From: Laura Gibbons
Sent: 25 January 2019 11:33
To: Simon Davis <Simon.Davis@arun.gov.uk>
Subject: RE: Y/92/18/DOC- Further Drainage Supporting Info

L-Bloc® / 1.2m / Reinforced

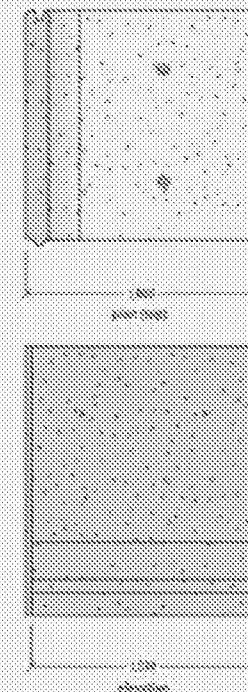
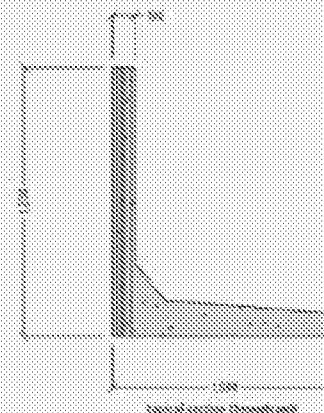
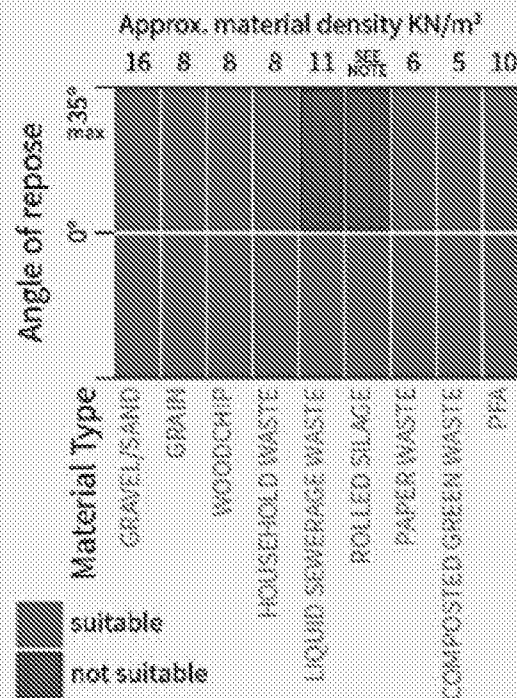
5. Insufficient details of the flood barrier have been provided. Please provide site specific drawings which include the concrete slab base and connectivity to the barrier.
